INSPECTION REPORT

DATE OF INSPECTION: 2/17/2020

PROJECT NAME: Tiny Home Village and AIC

LOCATION: 105 Texas St. SE, Albuquerque, New Mexico, 87108

TEMPORARY SEDIMENT & EROSION CONTROL PLAN

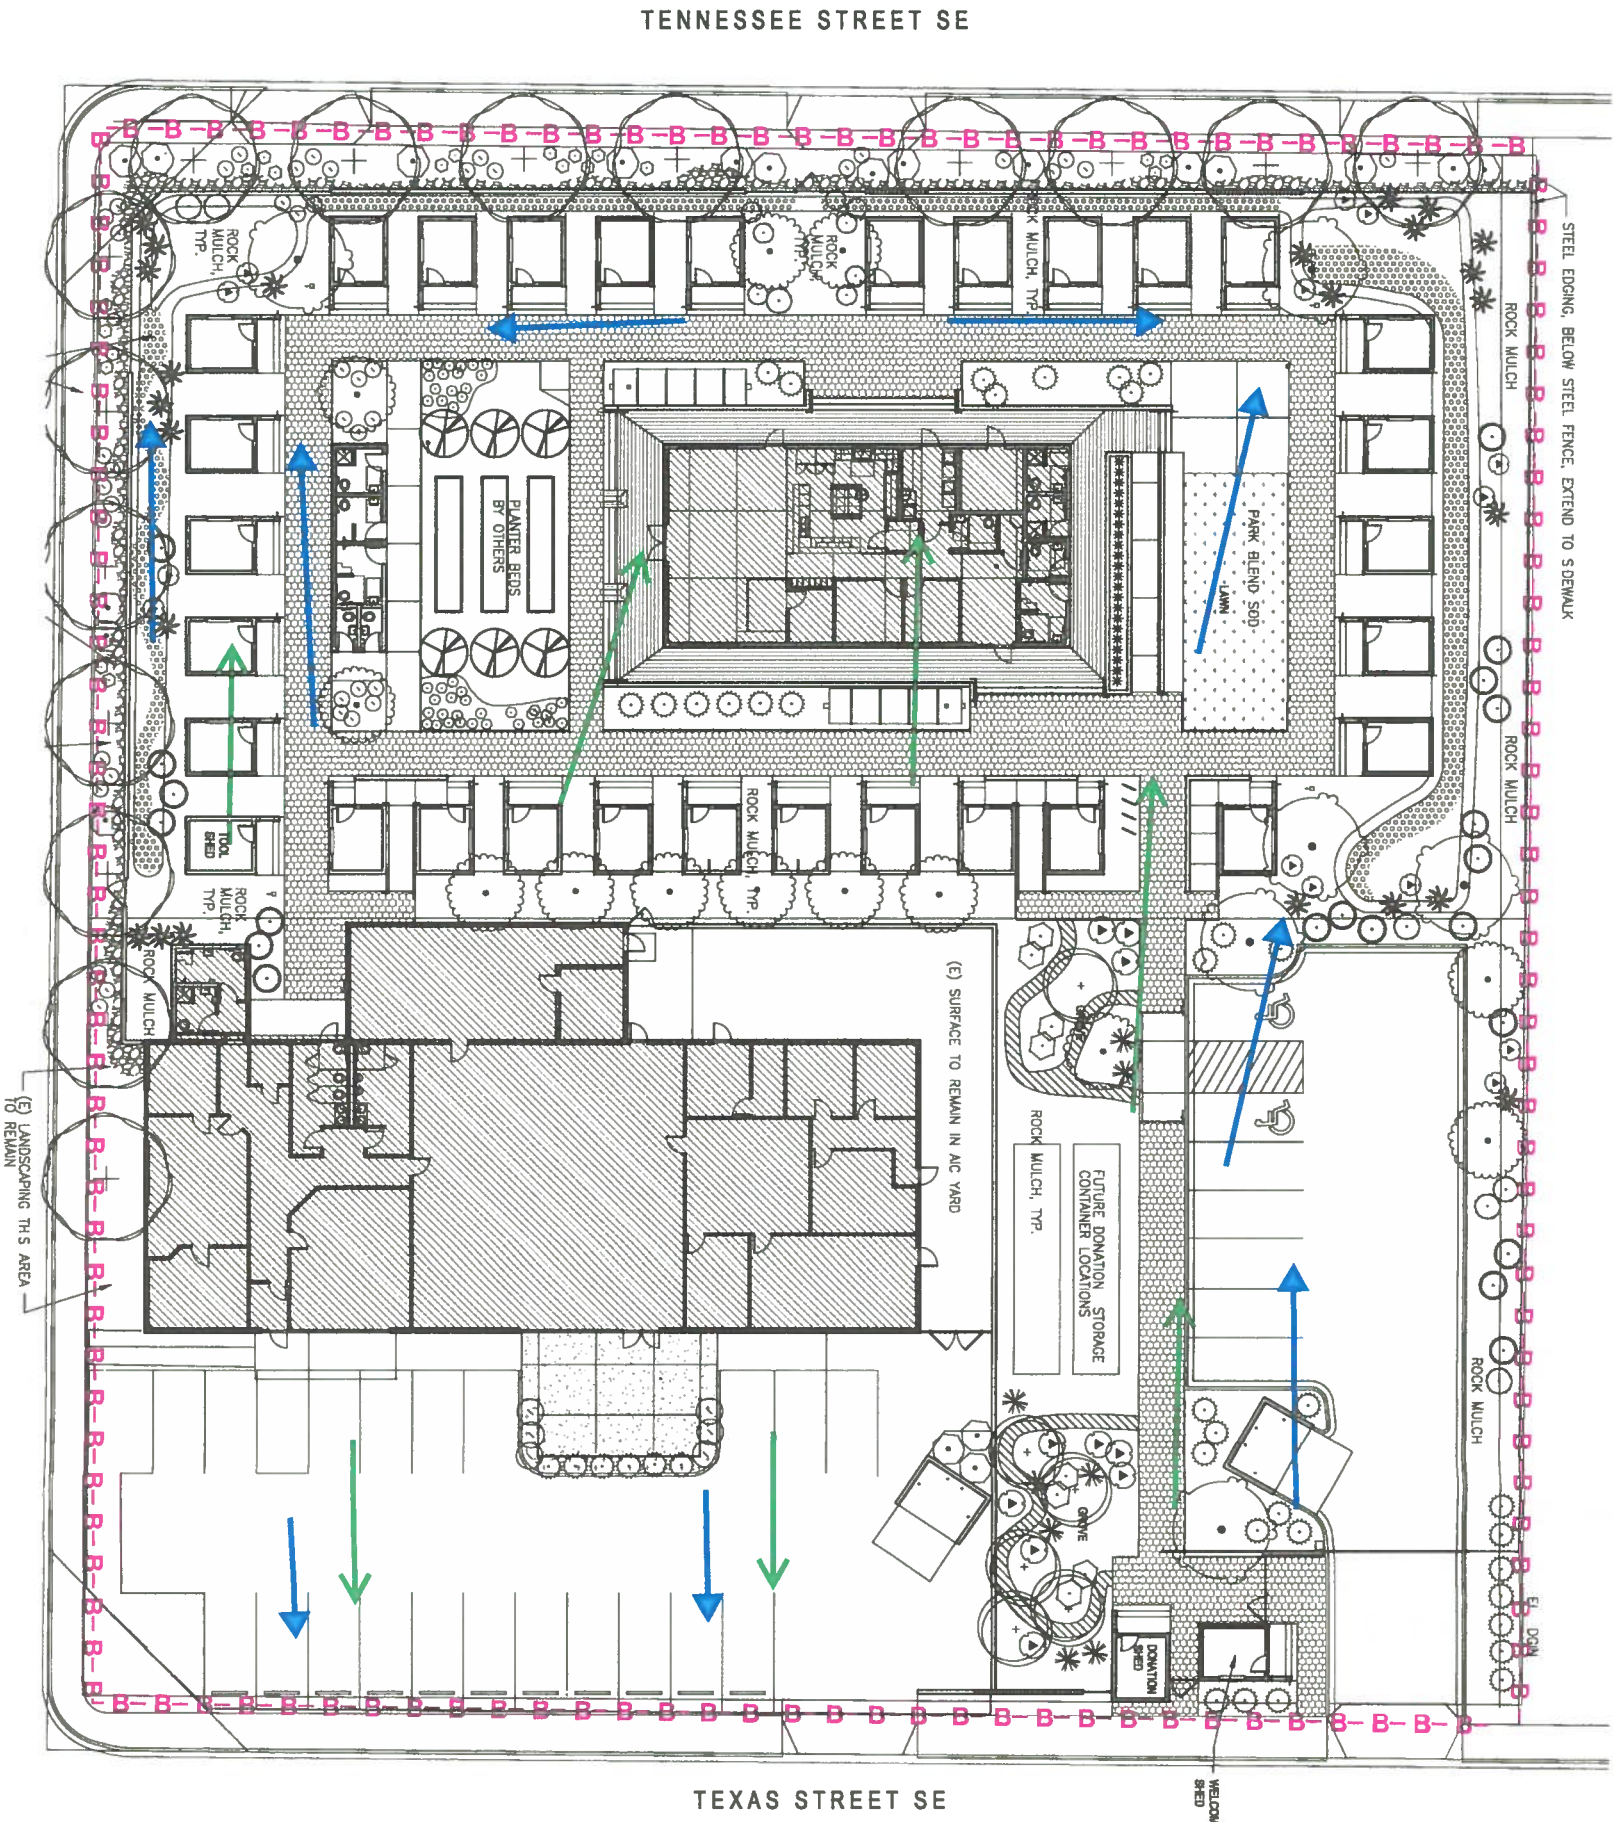
#	S&E/P2 CONTROLS	MAINTENANCE	CORRECTIVE ACTION	LOCATION	QUANTITY	UNIT	PHOTO
1	NPDES Permit Notification	None	None	Entrance	1	EA	Yes
2	Silt Fence	None	None	Perimeter	1000	LF	Yes
3	Inlet Protection	None	Initial Install	Zuni St. SE & Tennessee St. SE	1	EA	Yes

#	INSPECTION ITEM	INSPECTOR'S OBSERVATION	ACTION REQUIRED?	NOTES
1	Is the SWPPP signage clearly posted with the correct information and properly displayed at an obvious perimeter location?	<input checked="" type="radio"/> Yes <input type="radio"/> No <input type="radio"/> N/A	<input type="radio"/> Yes <input checked="" type="radio"/> No	0.10 in collected from rain gauge.
2	Are steep slope areas not actively being worked properly stabilized?	<input type="radio"/> Yes <input type="radio"/> No <input checked="" type="radio"/> N/A	<input type="radio"/> Yes <input checked="" type="radio"/> No	
3	Are disturbed areas not actively being worked properly stabilized?	<input checked="" type="radio"/> Yes <input type="radio"/> No <input type="radio"/> N/A	<input type="radio"/> Yes <input checked="" type="radio"/> No	Areas are currently being worked on.
4	Are natural resource areas (e.g. streams, wetlands, mature trees, etc.) protected with barriers or similar BMPs?	<input checked="" type="radio"/> Yes <input type="radio"/> No <input type="radio"/> N/A	<input checked="" type="radio"/> Yes <input type="radio"/> No	Inlet protection on Zuni St SE needs to be initially installed.
